Environmental Health Consultation Response		Officer	Heather Barton	
Detail: Proposed raised terrace to rear		039738		
Address:			 Ribble Valley Borough Council www.ribblevalley.gov.uk	
Application Ref:	3/2018/0595	Case Officer:		Mr Adam Birkett
Response Ref:	3/2018/0595/ENV/01	Issue Date:		19 July 2018

Proposed Terrace

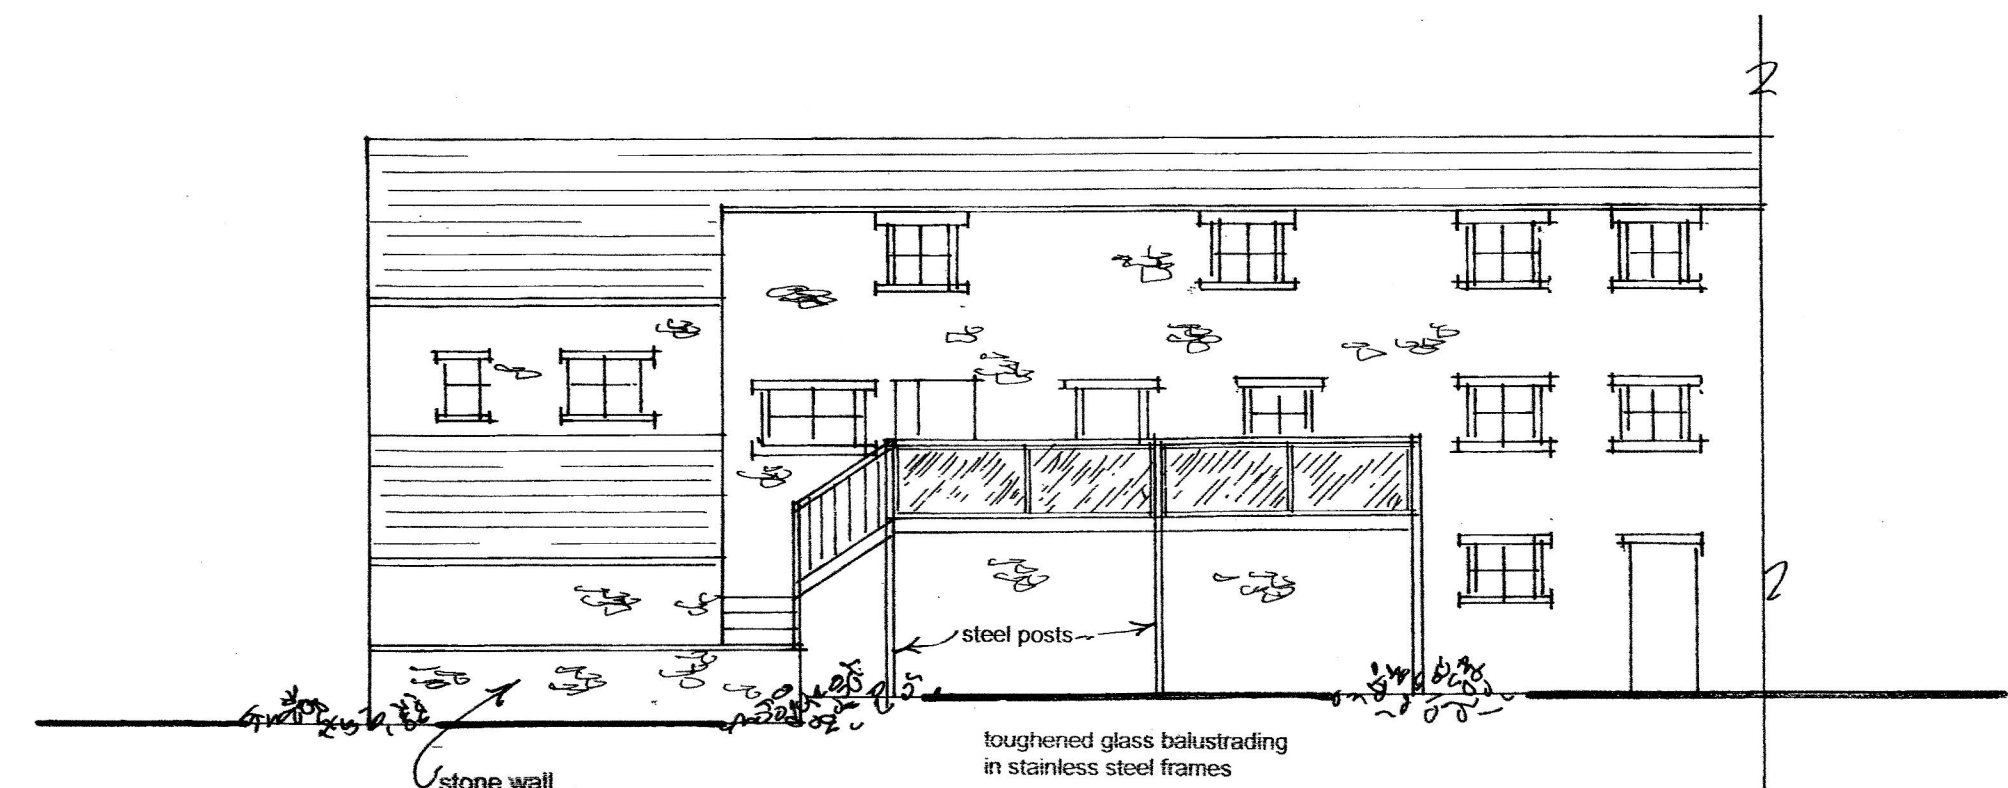
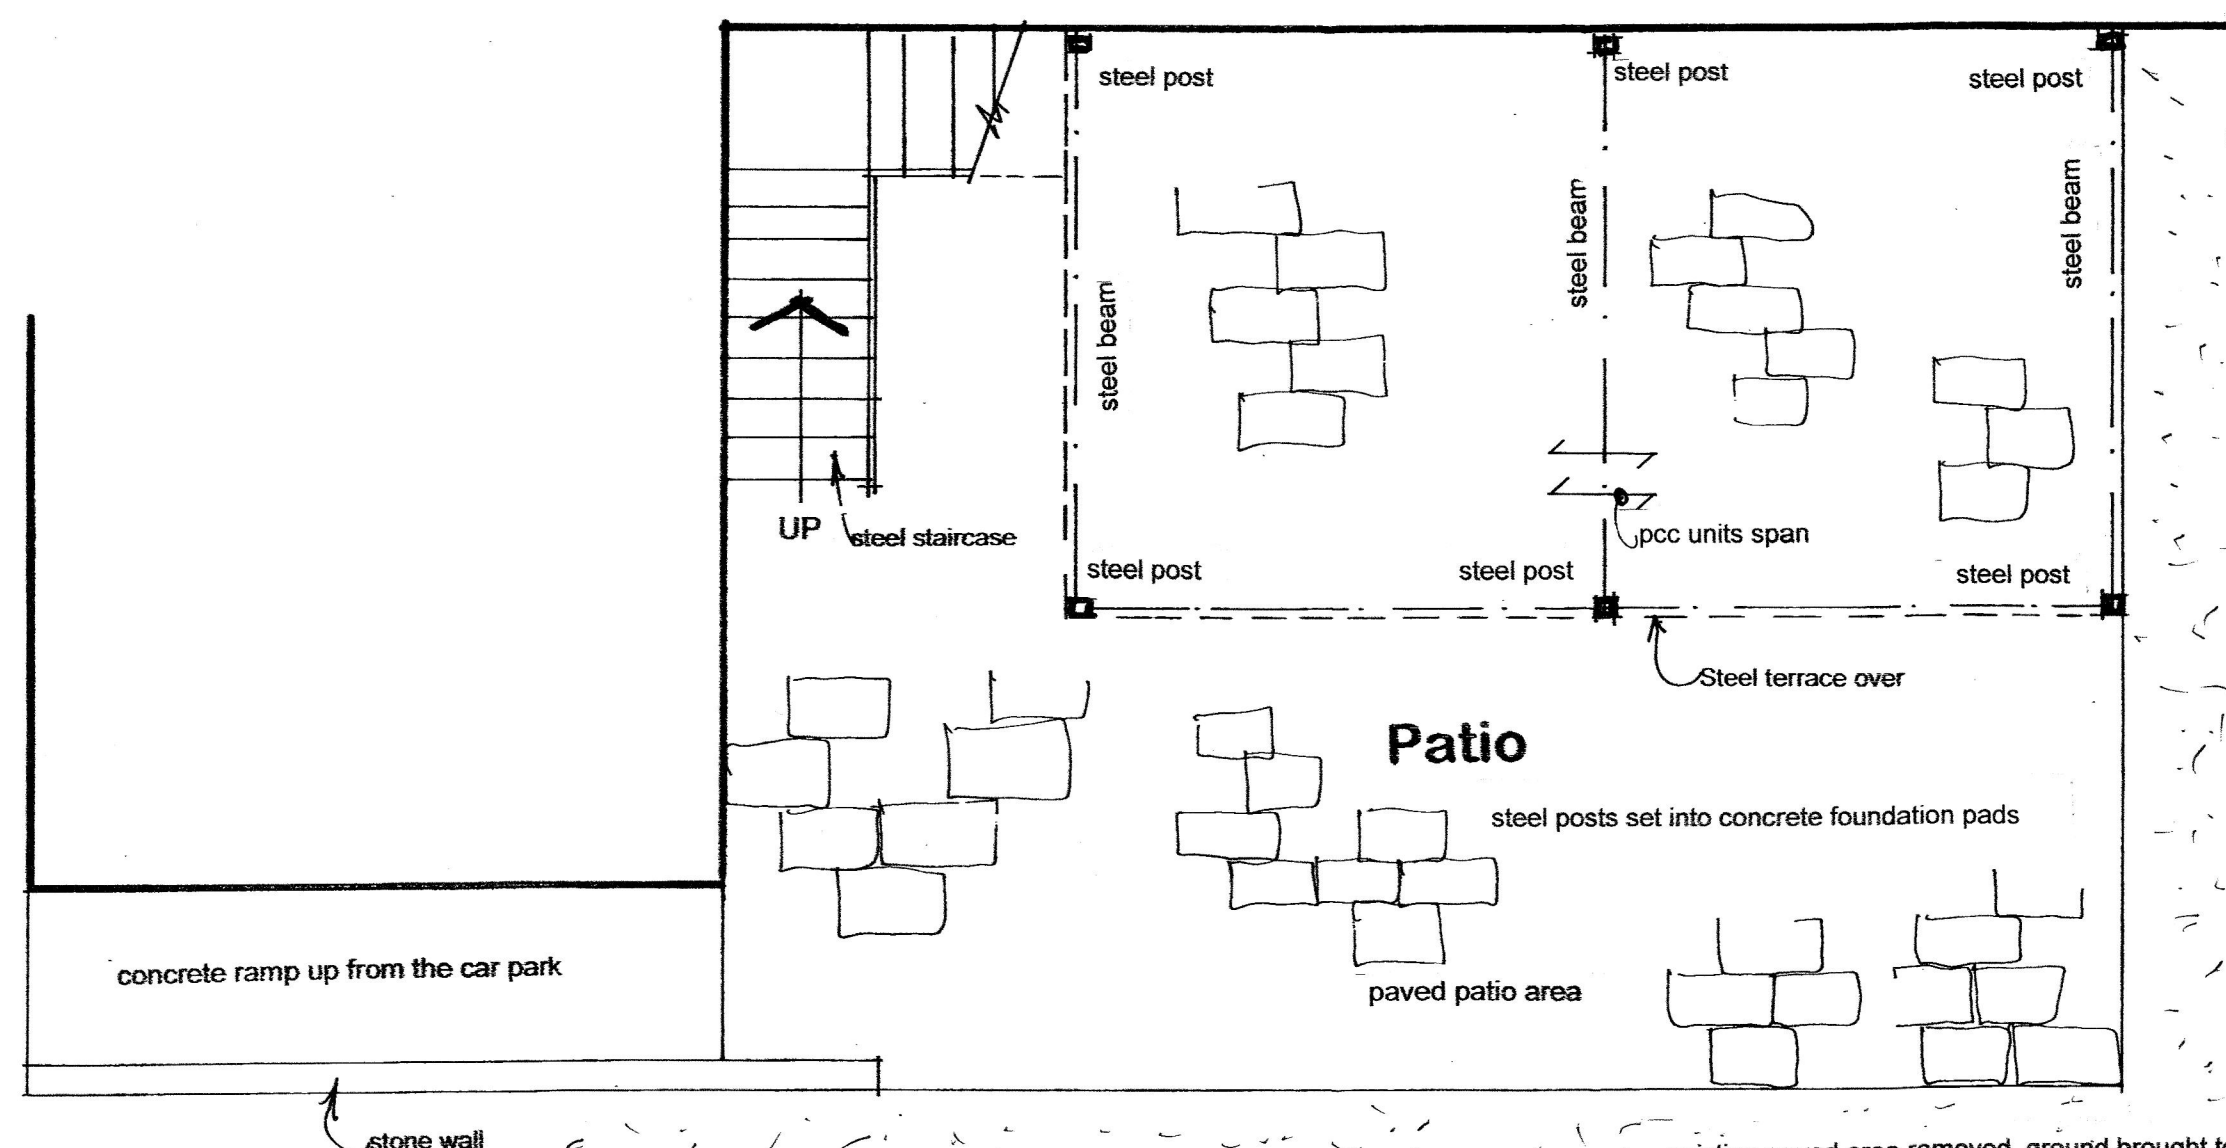
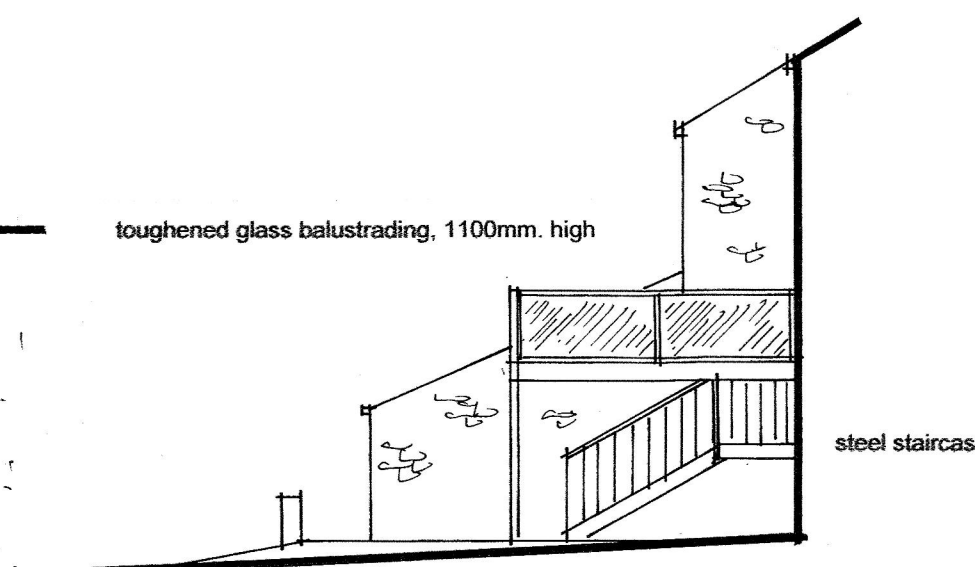
General Comments/Observations	
<p>1.1 The elevation of the decking area may contribute to noise being audible outside the curtilage of the property</p>	
Suggestions/Mitigation	
<p>2.1 Environmental health request a noise impact assessment</p> <p>2.2 Environmental Health would ask the applicant for conditions for the hours of use</p>	
Conclusions/Suggested Conditions	
<p>2.3 The above observations have been provided on the basis of the level of information submitted and the comments contained within this response represent officer opinion only, at the time of writing, without prejudice.</p>	
	Officer: Heather Barton
